**Re: Drainage submittal for vacation of temporary drainage
easement on Lot 1E, Broadway Industrial Center, Unit 2,
(M-14/D12E).**

**Re: Grading and Drainage Plan for Broadway Industrial Center, Lot 1E, Unit 2
Engineer's Stamp Dated 1-11-02, (M14/D12E)**

**Re: Grading and Drainage Plan for Broadway Industrial Center, Lot 1E, Unit 2
Engineer's Stamp Dated 1-11-02, (M14/D12E), Revised Plan & Letter Dated 2-28-02**

## GRADING & DRAINAGE PLAN

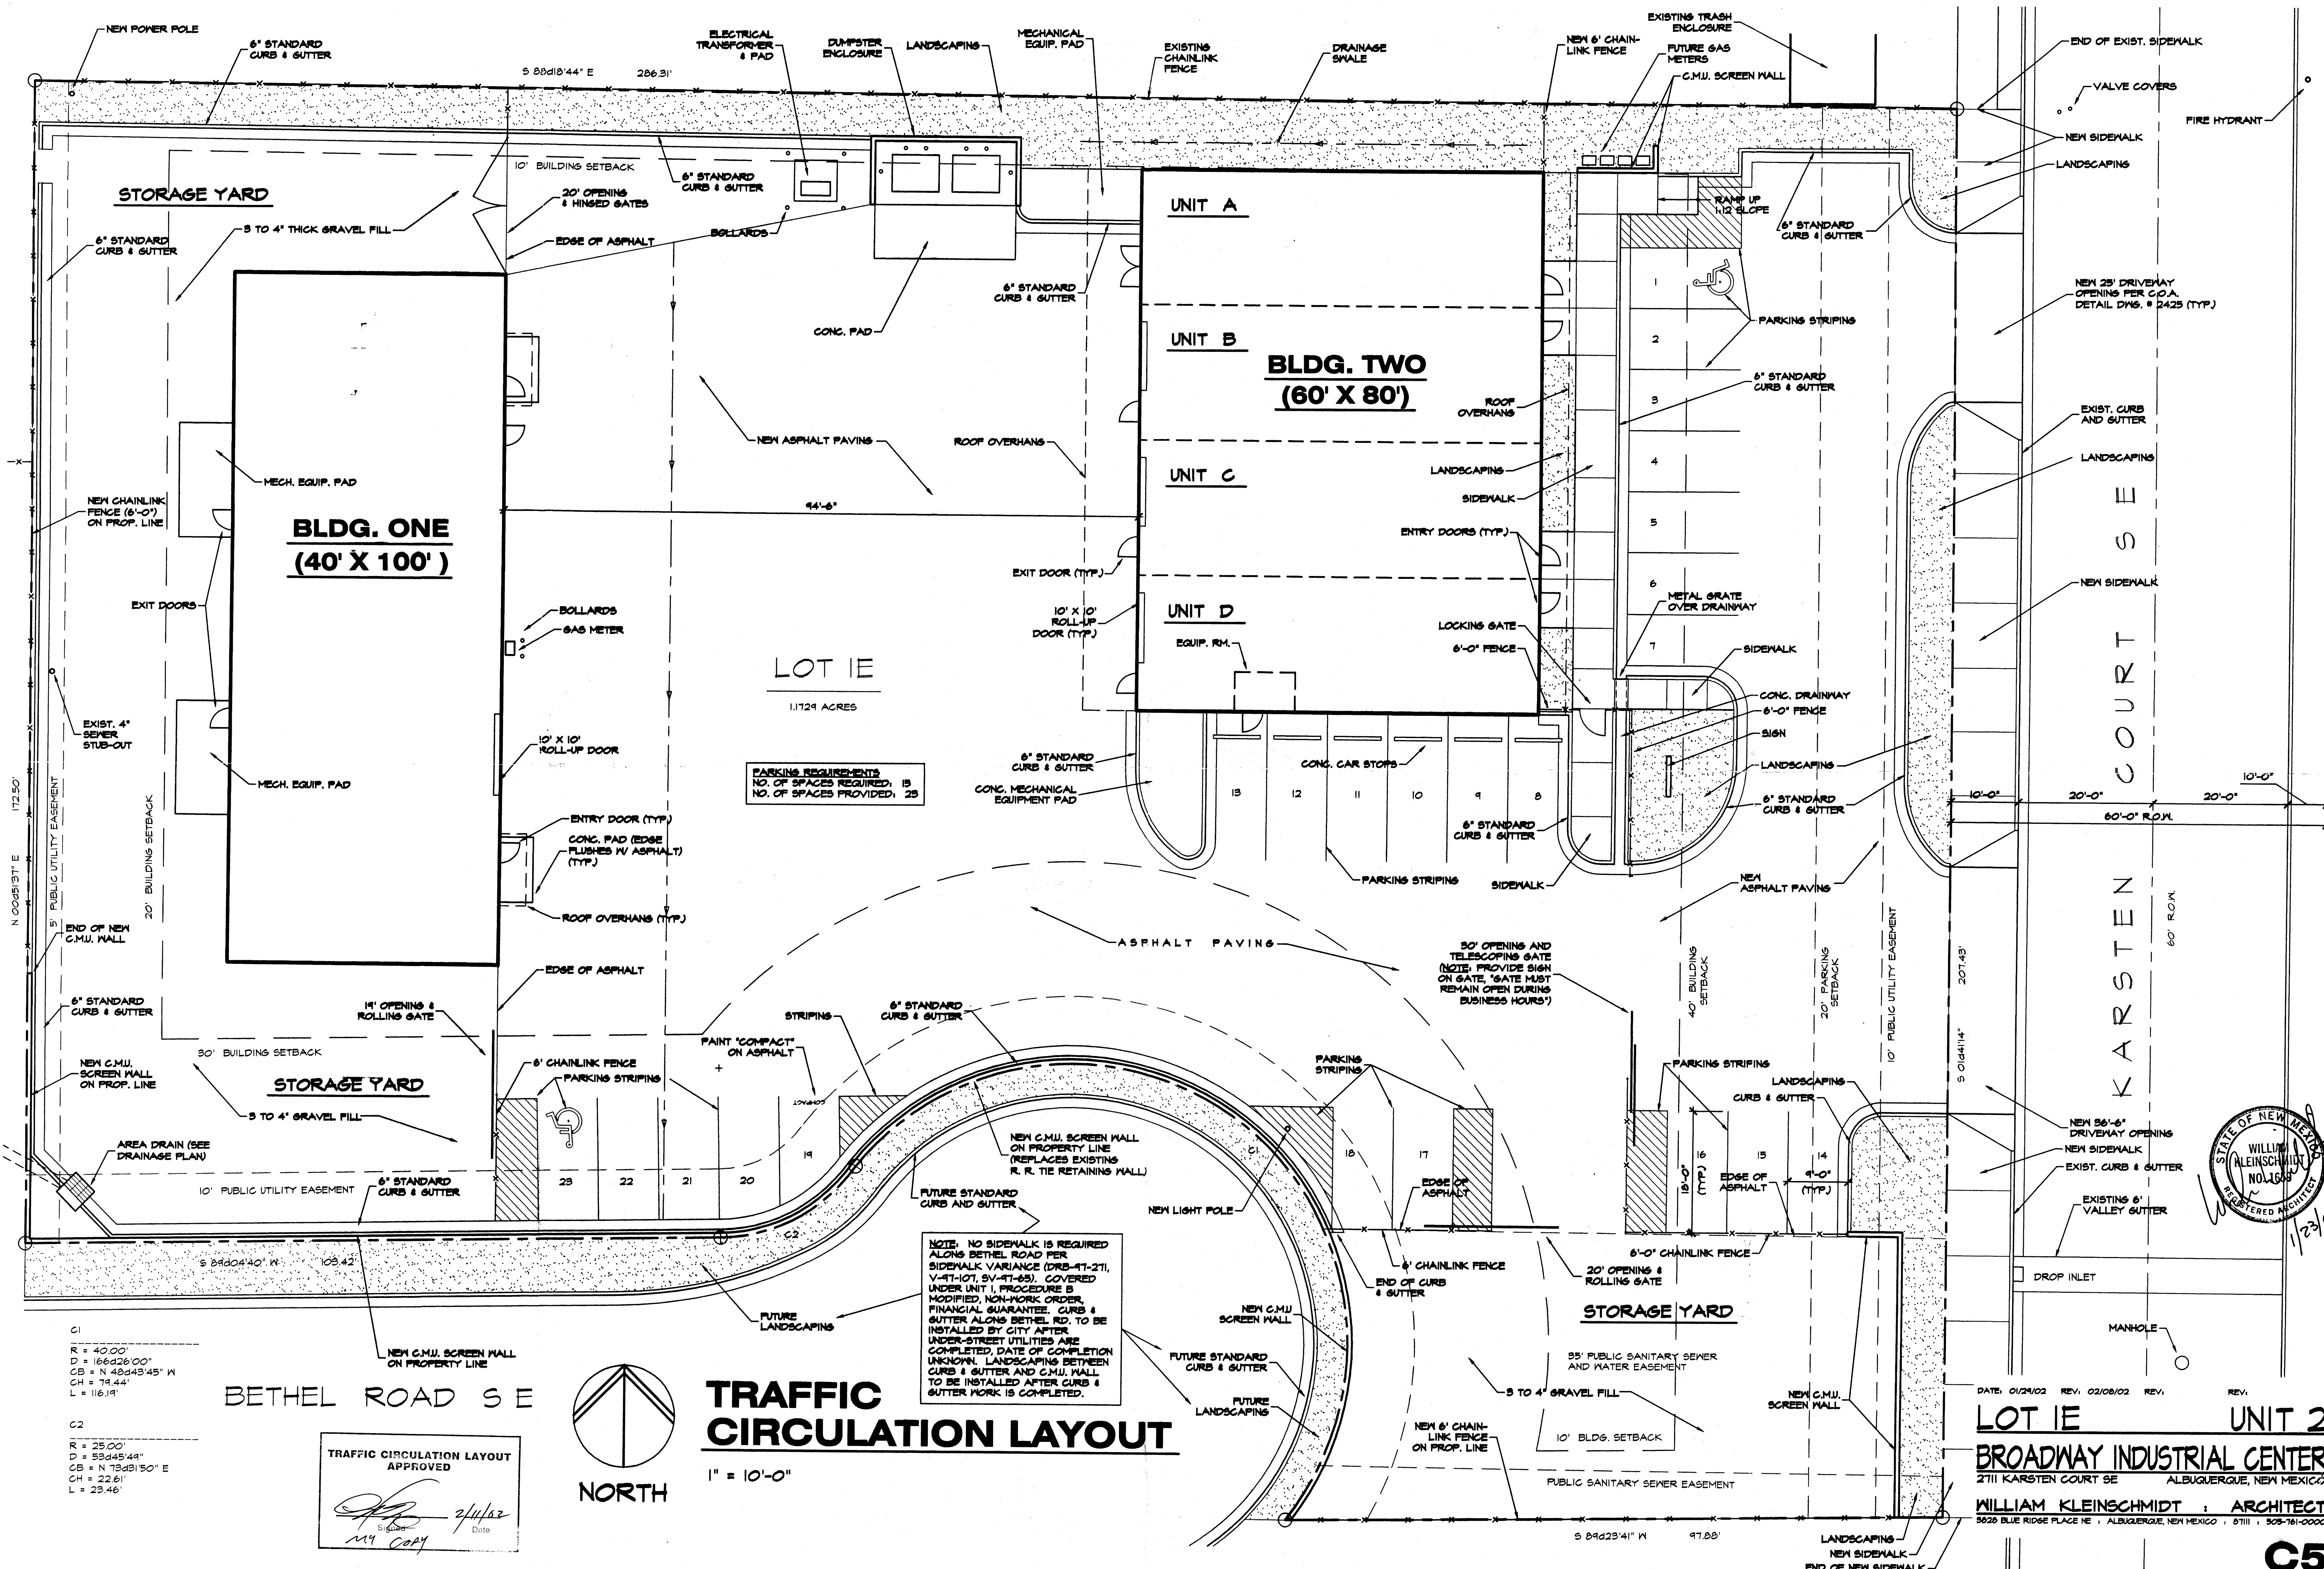
- Please quantify off-site flows from north lot.
- Show cross section and more elevations for retaining wall on south side of site near Bethel Road.
- How much of Bethel Road are you building?
- How much flow is entering the pond from lot 1E and from other lots? Is the pond capacity enough to hold all on site and offsite runoff?
- Please submit an easement agreement to pond into lot 1B2 and a covenant agreement for the pond storm drain maintenance.
- Explain why there only needs to be a .4' high water block on the northeast driveway entrance? Minimum is 1 foot.
- Please show storm drainpipe system for the existing drop inlet in the southeast side of the site near Karsten Court. Where does this storm sewer drain?
- Does the future storm drain on Bethel Road financially guaranteed?

1. All off site flows were quantified in previous reports and this site is not effected by off site flows.
2. A cross section has been added for the retaining wall on the south side near Bethel Rd., and street slopes are shown between spot shots.

3. This project will not construct any of Bethel Rd. Broadway Unit 1 Financially Guaranteed the 1/2 street paving and Unit 2 Guaranteed the storm sewer in Bethel. The sidewalk on the north side of Bethel was waved with the preliminary plat approvals for those two Units.

4. As stated in the drainage Management Plans the 3-9-99 plan sized the pond and has already been approved. Flows from this site are summarized in the drainage Calculations shown on this plan.

5. Easement Agreements and provisions for maintenance of the pond on Lot 1B 2 were addressed at the time of subdivision.
6. The northeast driveway is within 100' of the high point in Karsten Ct. The 100yr flow there is contained in the gutter and does not even get deep enough to spread into the street. So the 4" high water block on that driveway allows some room for construction tolerances and a reduced height from the normal one foot water block is desirable because the street at that point is 4 feet above the site and the reduced water block prevent vehicles from bottoming out

7. ^{will} Flows from the Karsten Ct. inlet in the southeast corner of this site were originally contained in a 100' x 100' pond in the middle of this lot. That was changed by the Grading and Drainage Plans for Lots 1 & 2 which redirected the flow into the pond on lot 2A. The easement on Lot 1E was vacated by a Plat recorded two weeks ago (see attached). The agreement and covenant needs released for that original pond.

# TRAFFIC CIRCULATION LAYOUT

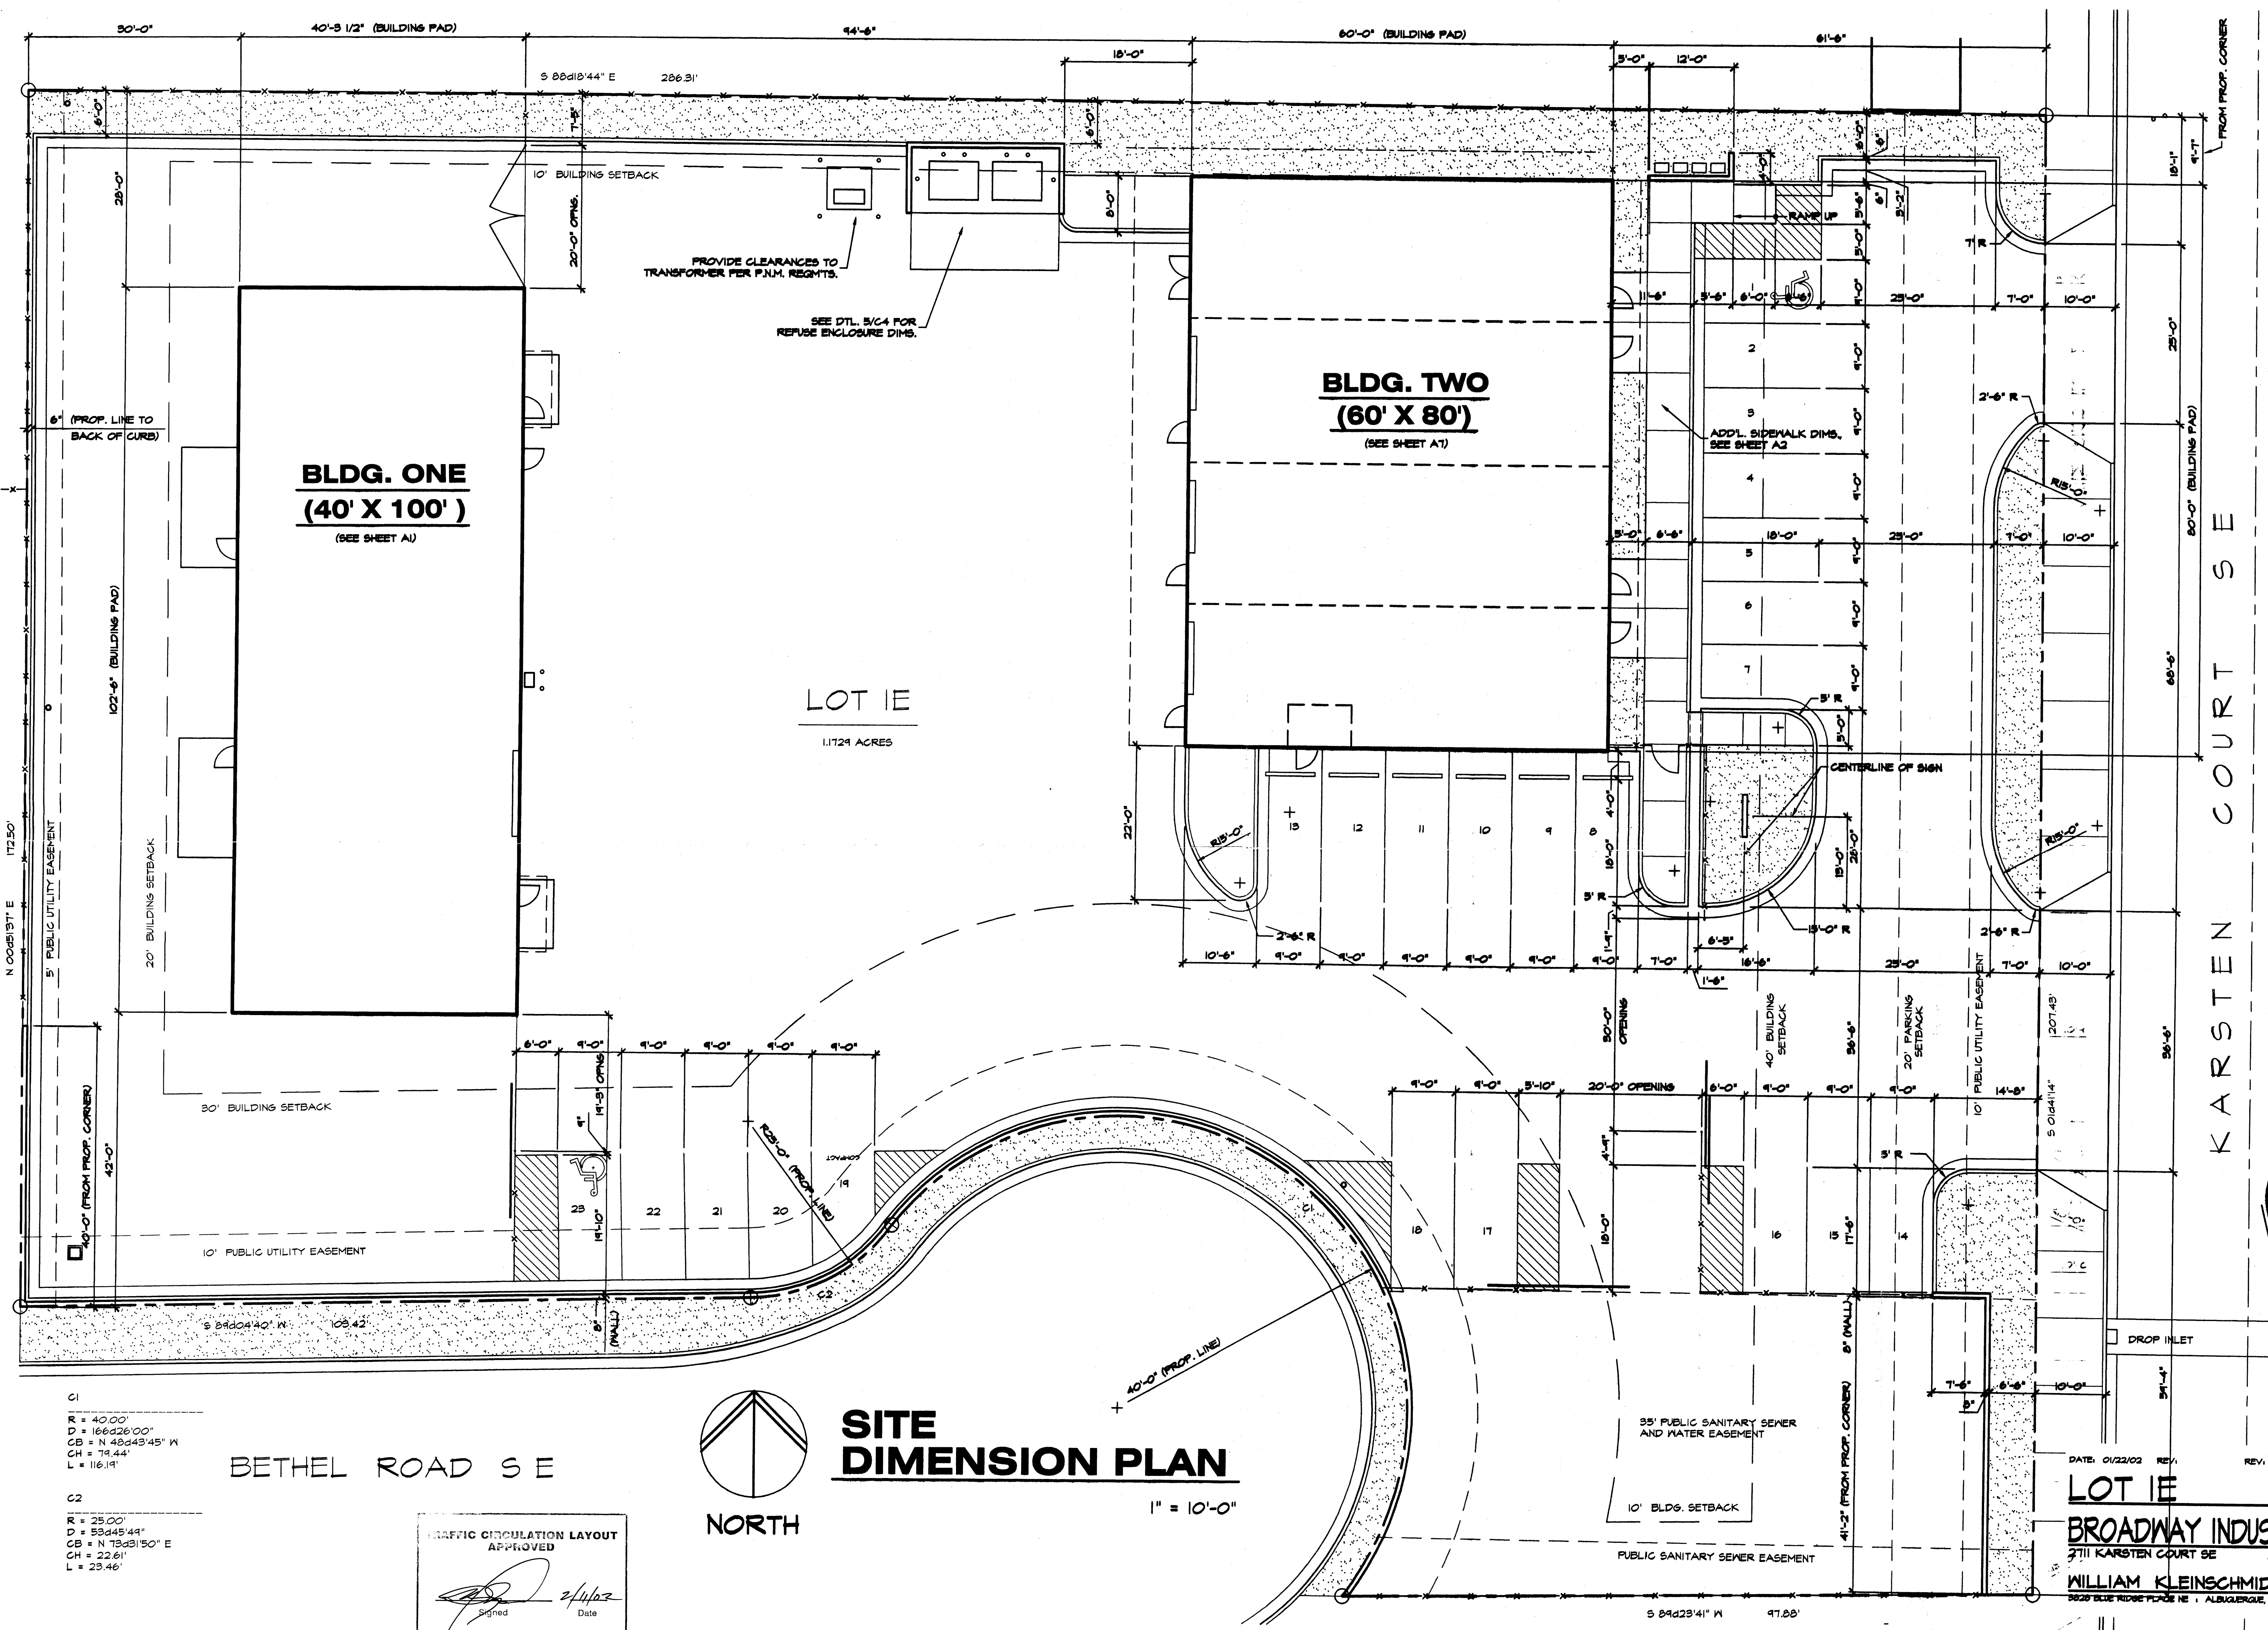
- The TCL submitted requires completion of the items not yet addressed on the checklist (marked in blue) or the original mark up and items marked up on the TCL revised by the designer. Sidewalk variance is acceptable, however, no mention is made of the standard curb and gutter construction--a component of overall street pavement construction, on Bethel Road, in the variance document.
- Confirmation of approved street design grades and paving section for Bethel Rd. is required prior to building permit approval. Grades should be approved by the Design Review Committee in this office.
- Financial Guarantee for paving and standard curb & gutter construction on Bethel Rd. will need to be on file with Arlene Portillo of Development and Building Services Section, also in this department.
